COLORADO
Department of Transportation

February 24, 2020

RE: The Sod Guy - AL1914_Lot 1 of the Appaloosa Highway 24 Subdivision filing No. 1A: **REVISED**

THE SOD GUY - SALES LOT
SITE PLAN

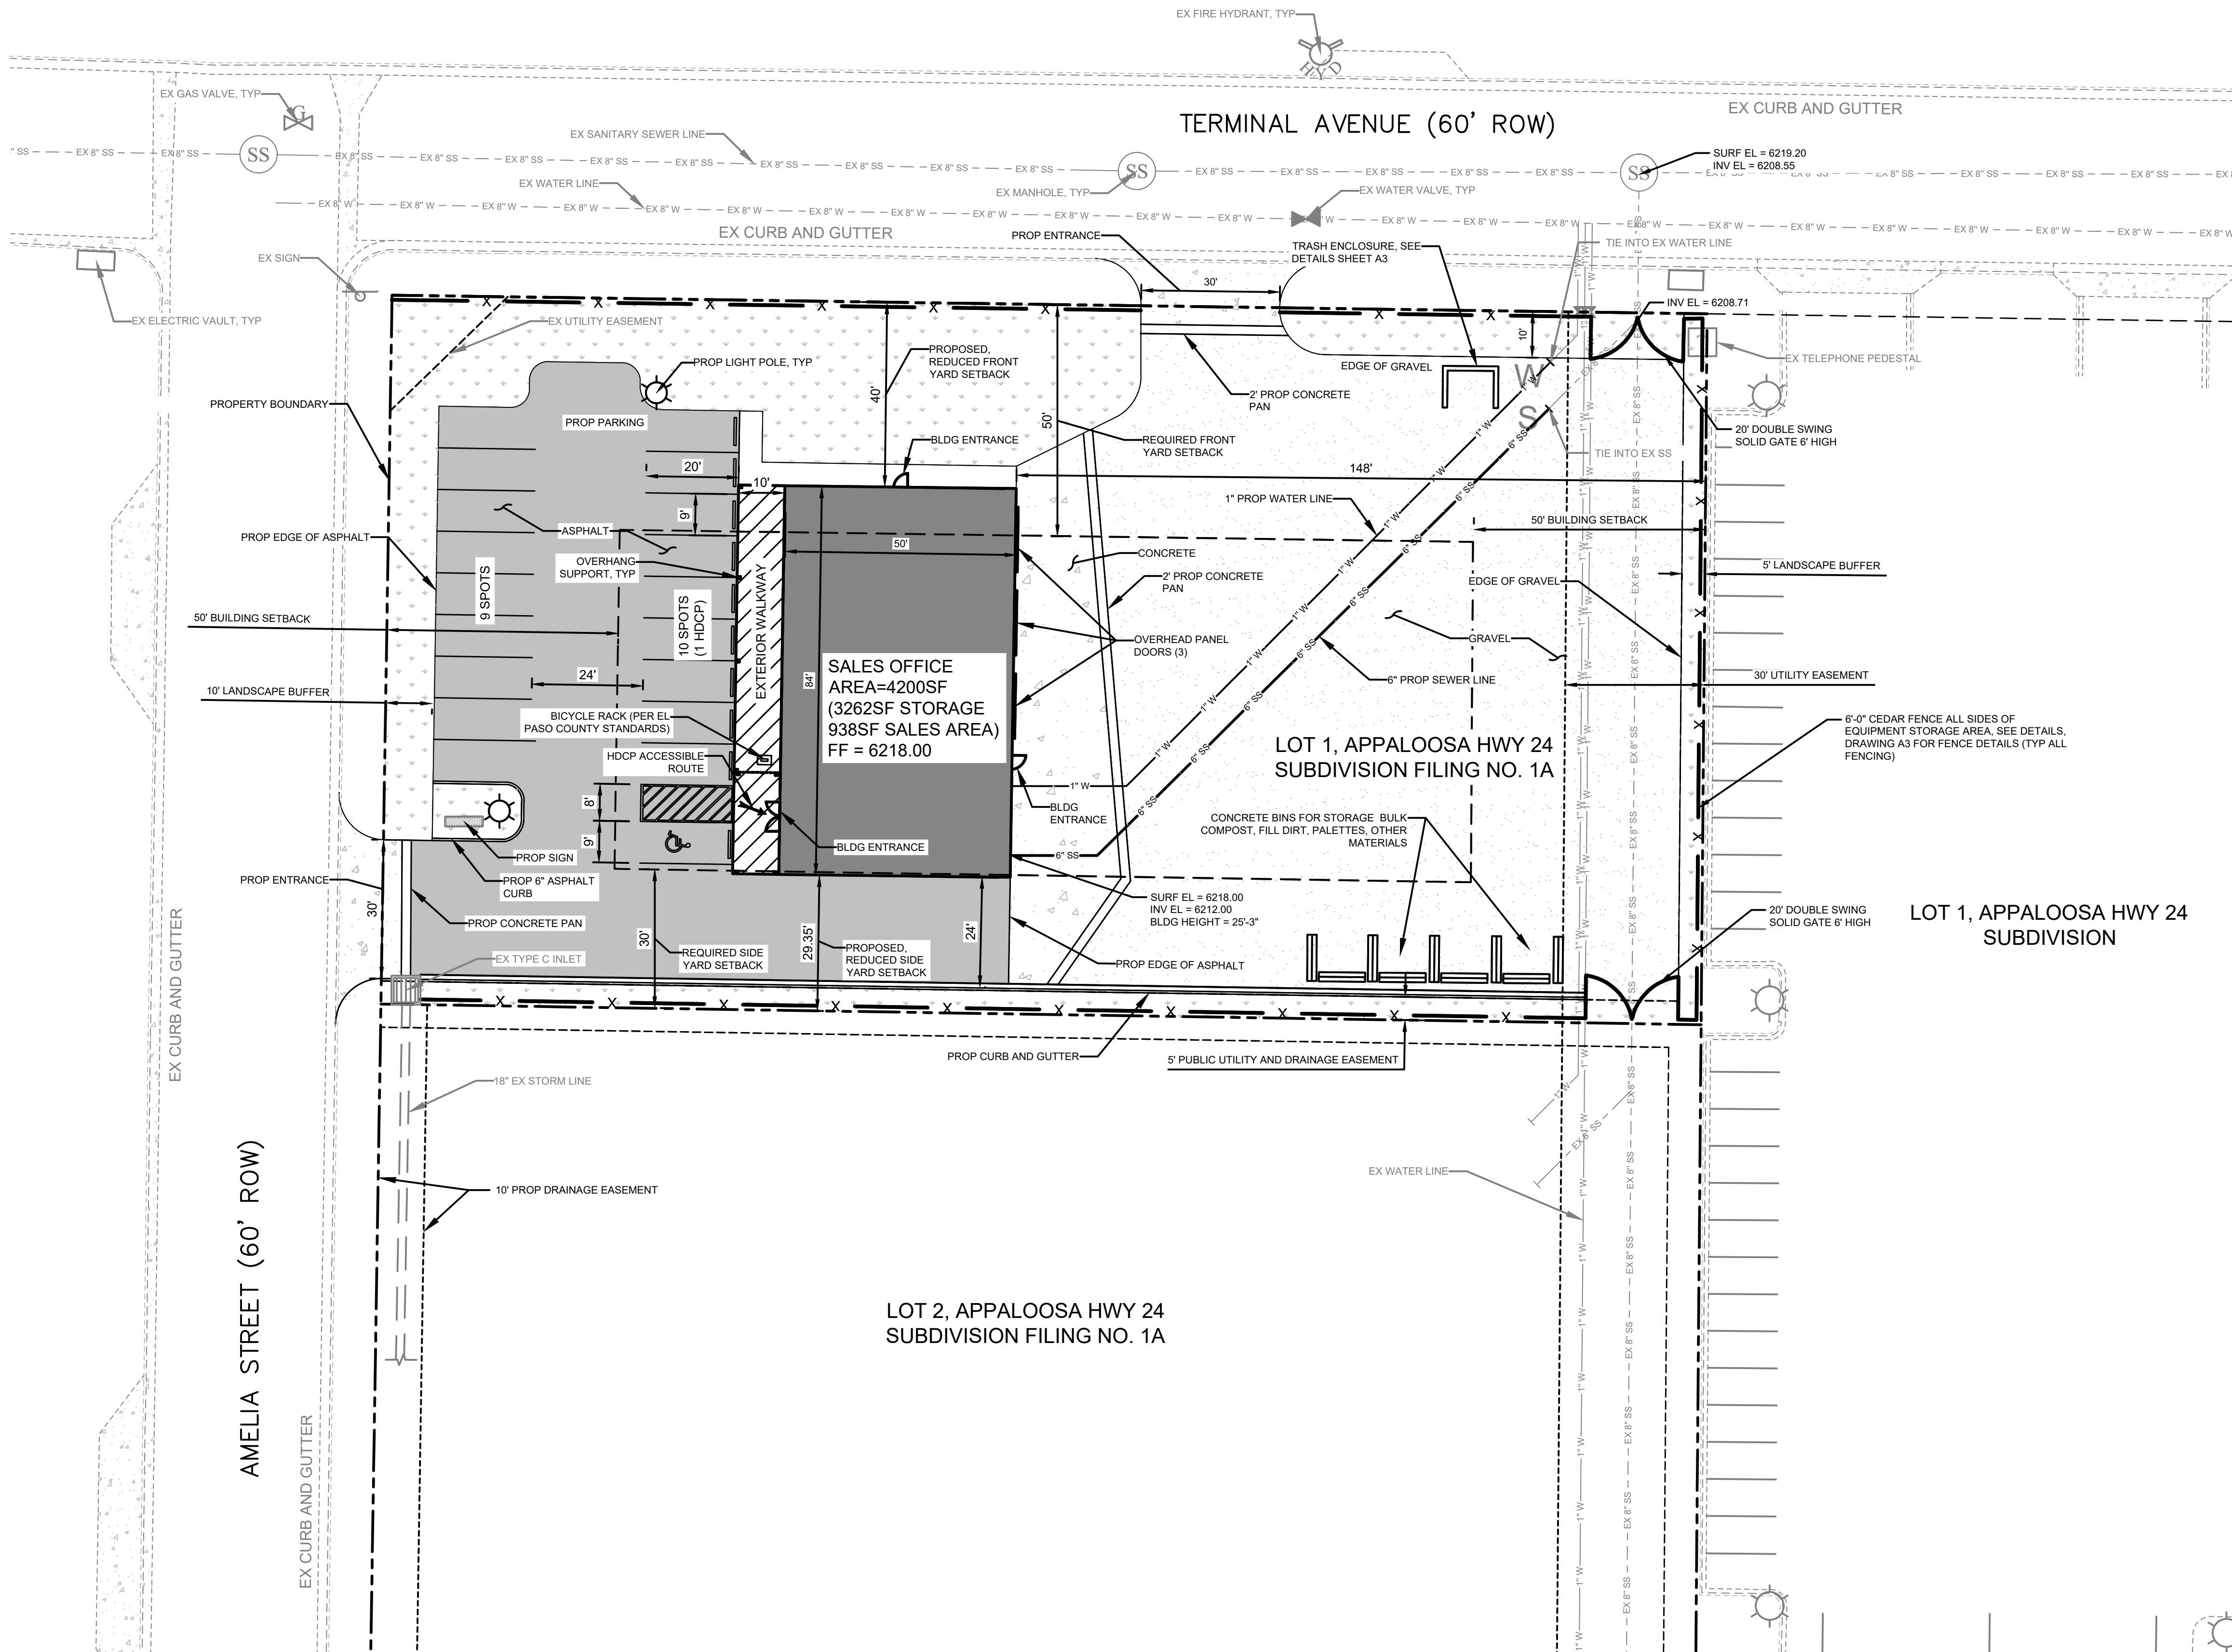
- **Access comments:**
 - a. The Sod Guy will be required to apply for a Utility Permit to address the potential drainage issues with the tie in to the existing drainage system in CDOT ROW
 - b. Other requirements will be required by El Paso County of the developer as condition of approval.
